**Subject:** RE: Planning Consultation on: M/39/22/DOC

**Application No:** M/39/22/DOC  
**Registered:** 11th April 2022  
**Site Address:** Briarfield Ancton Lane Middleton-on-sea PO22 6NL  
**Description of Works:** Approval of details reserved by condition imposed under M/141/21/HH relating to condition 5-surface water drainage.

At this stage we **would not recommend discharge of conditions** until the following comments are addressed.

Percolation Tests No. 1 2 & 3

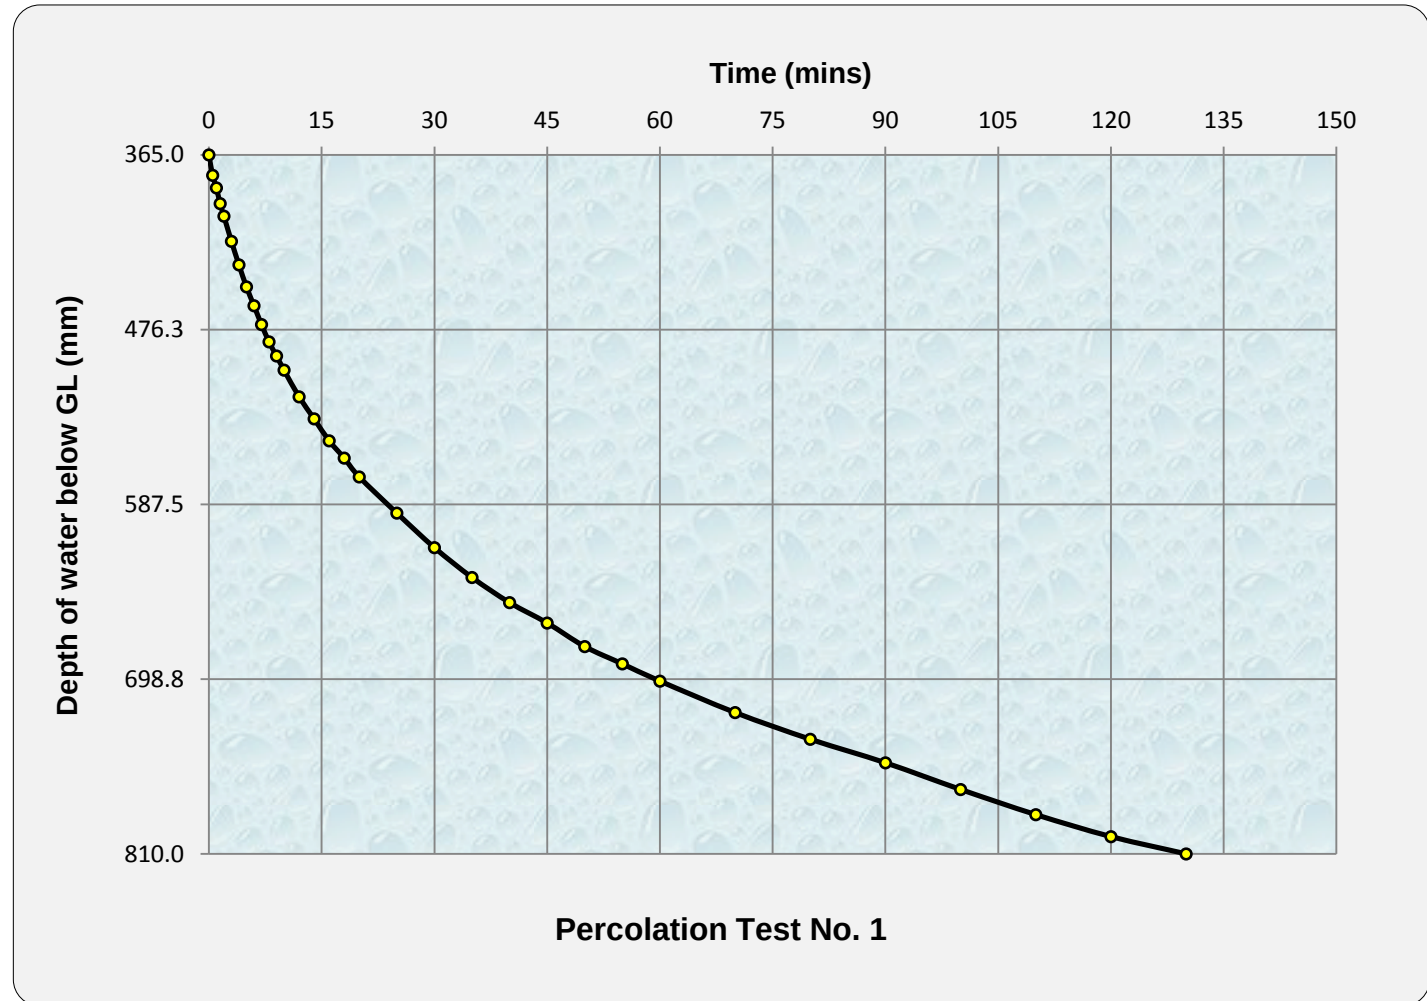
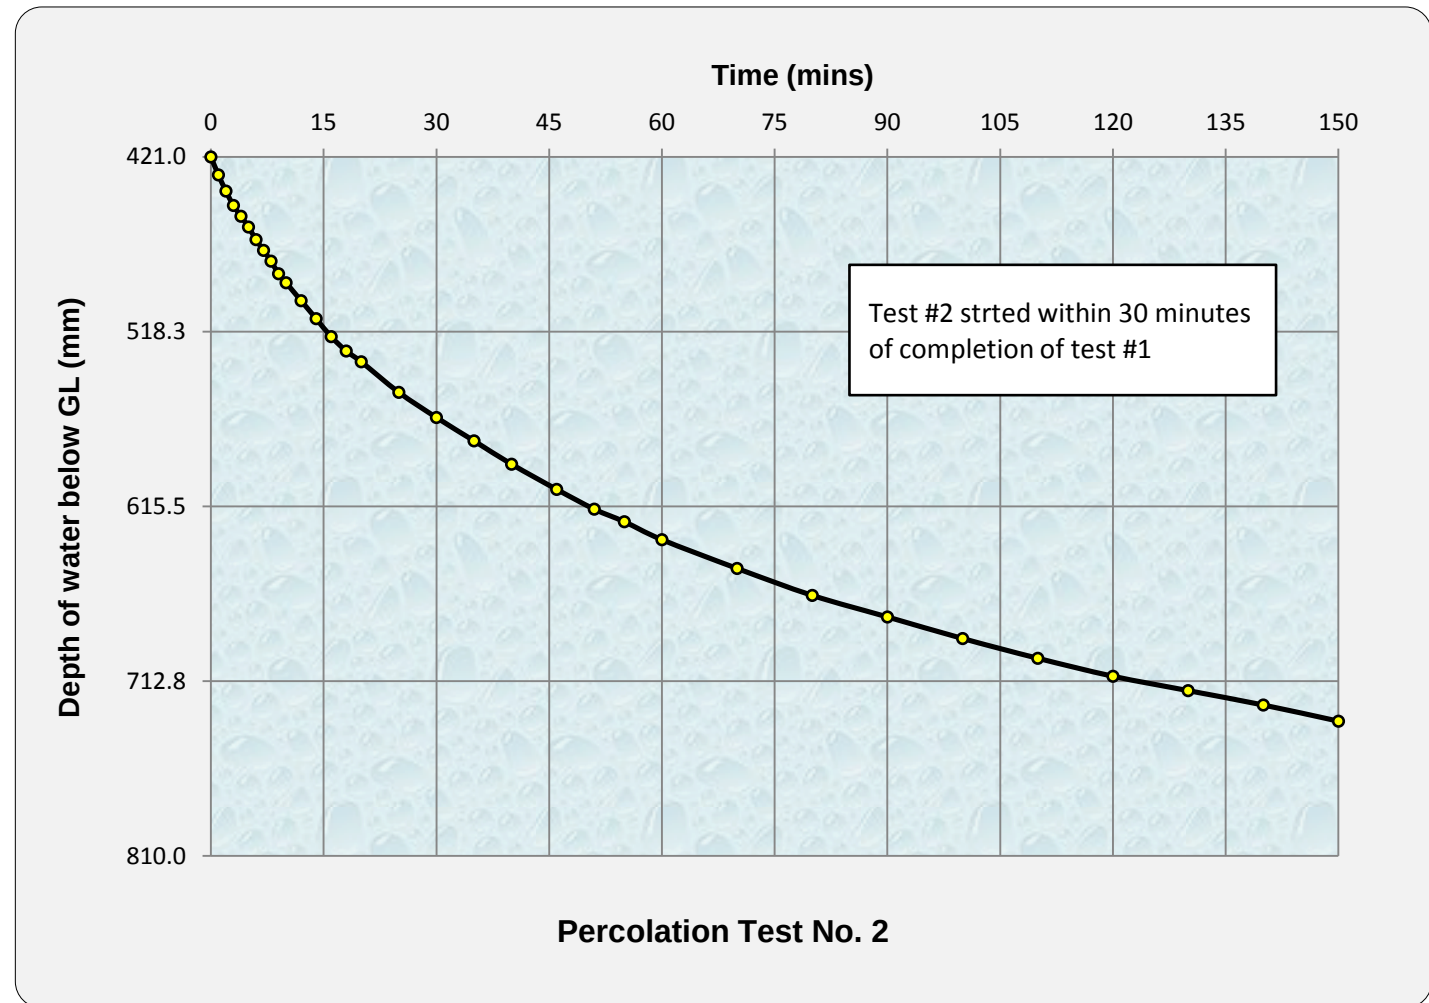
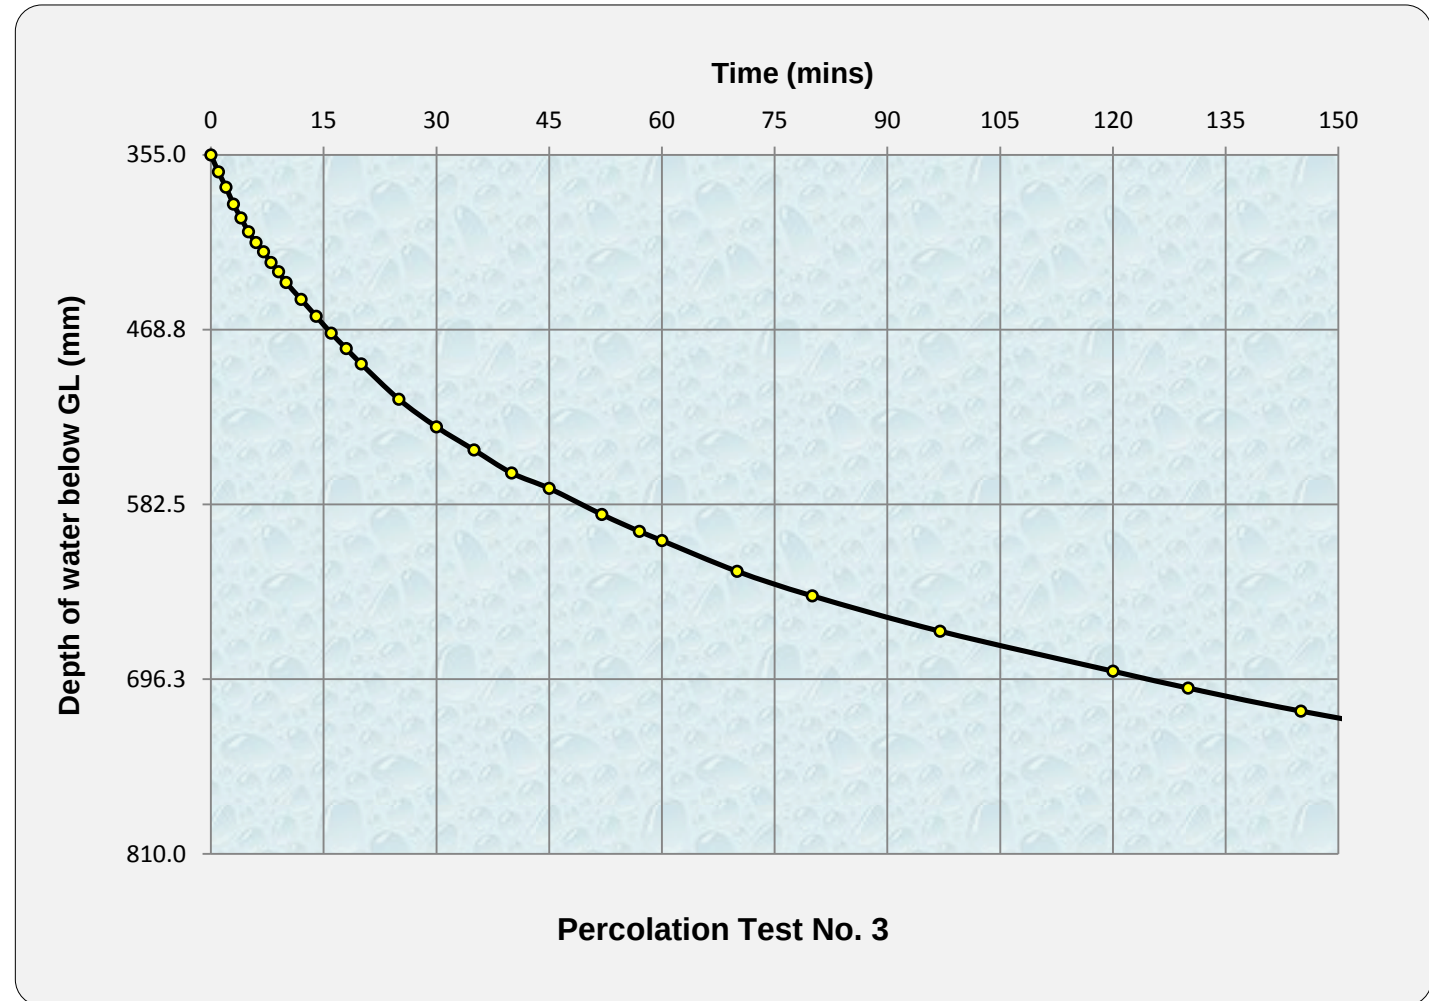
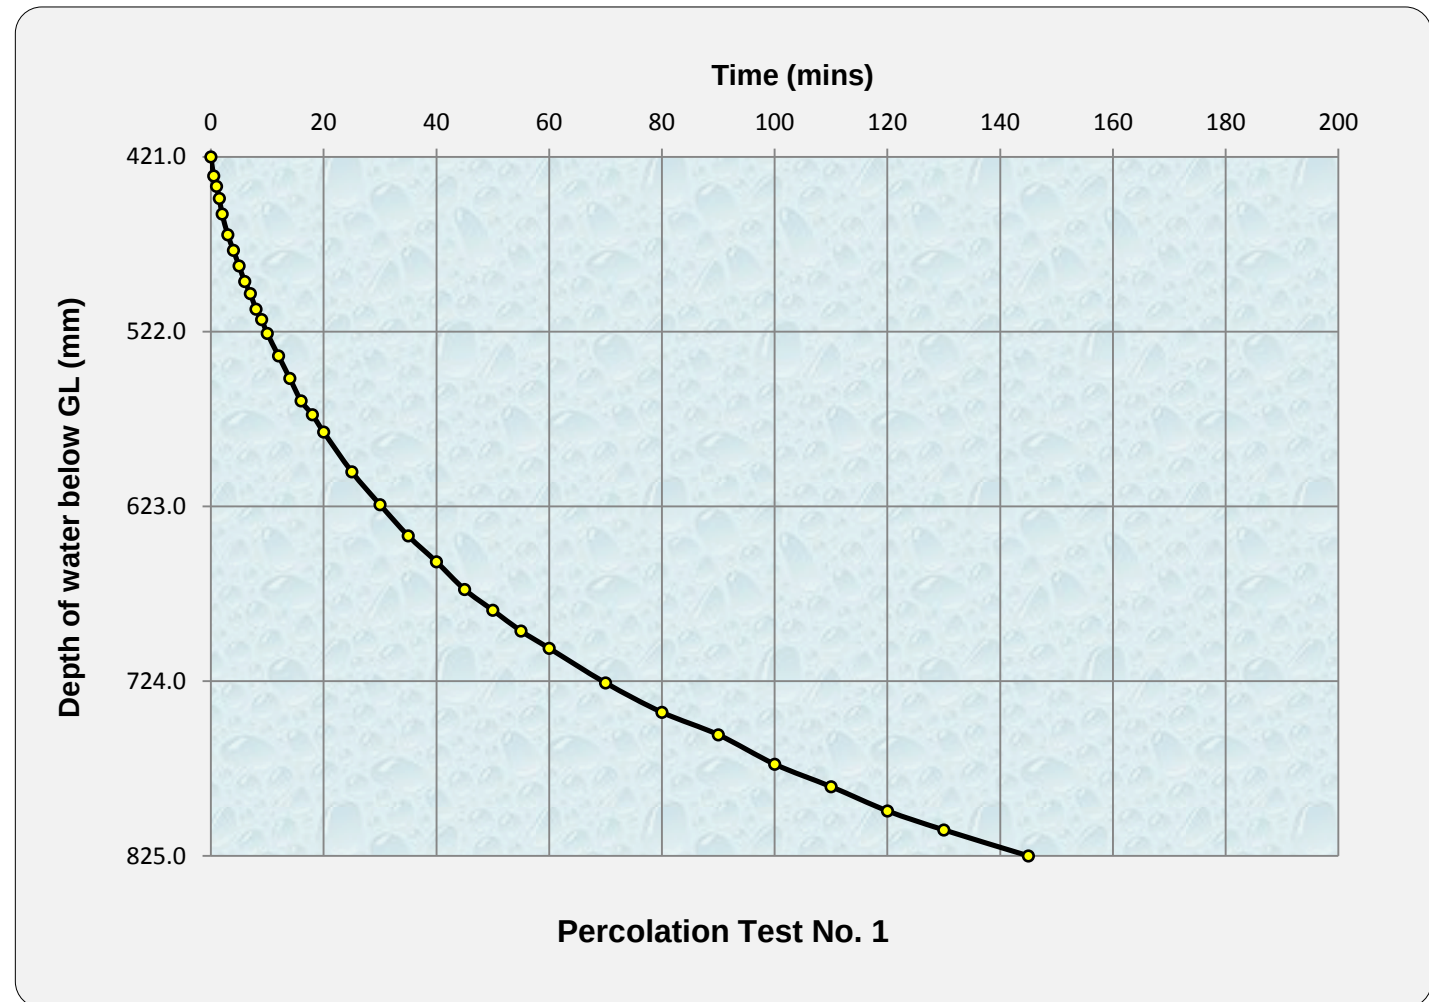
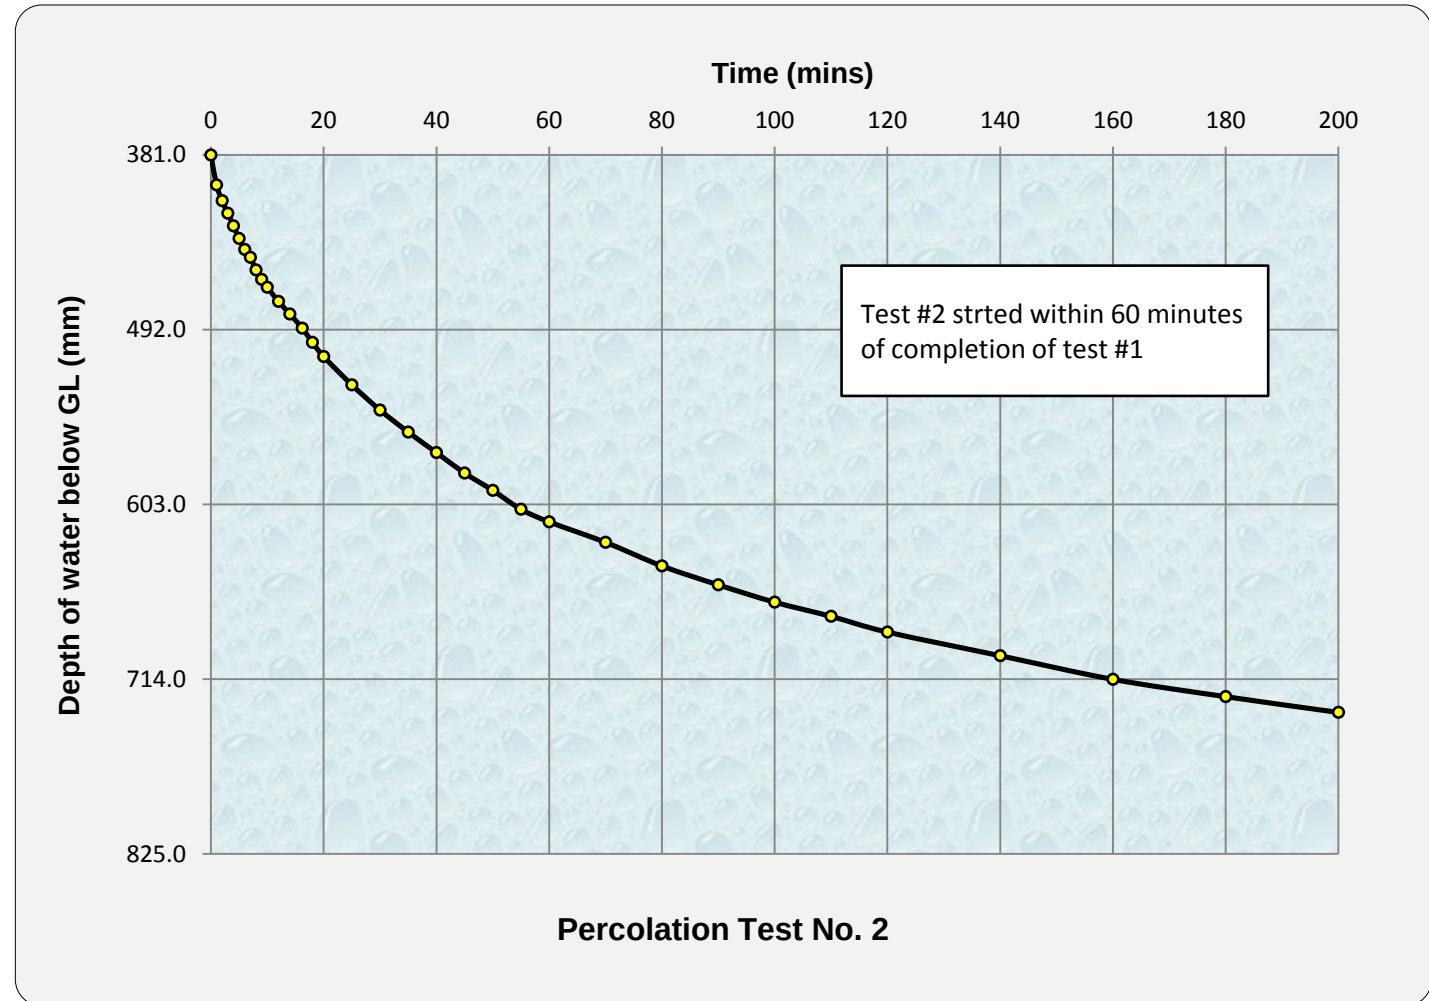
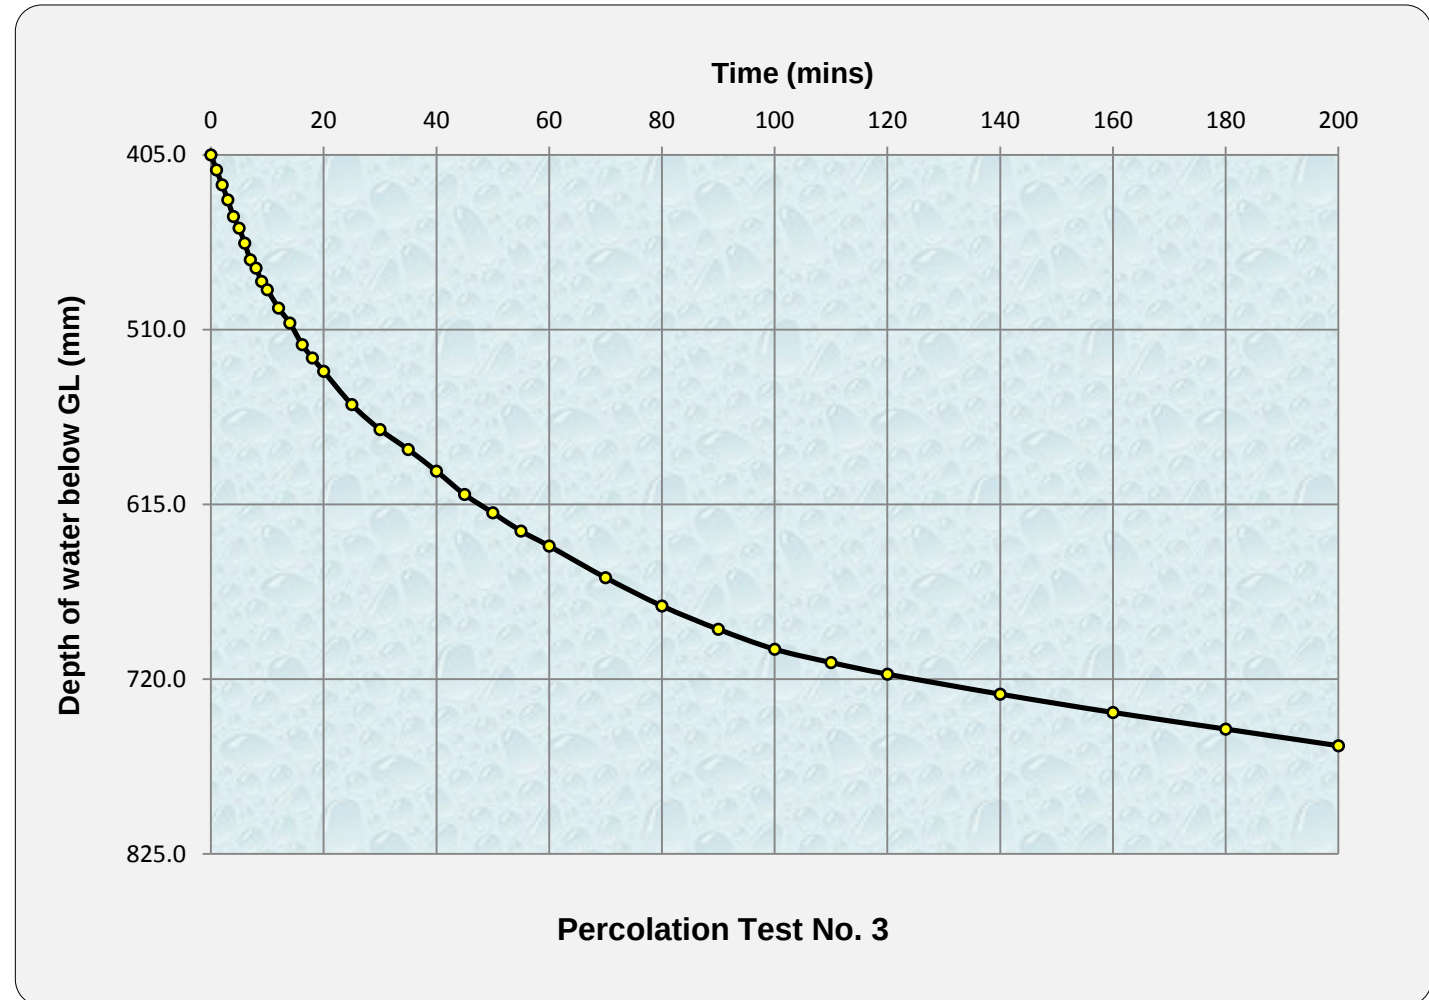
8. The infiltration test results should include the 75% and 25% drain down times for each test.
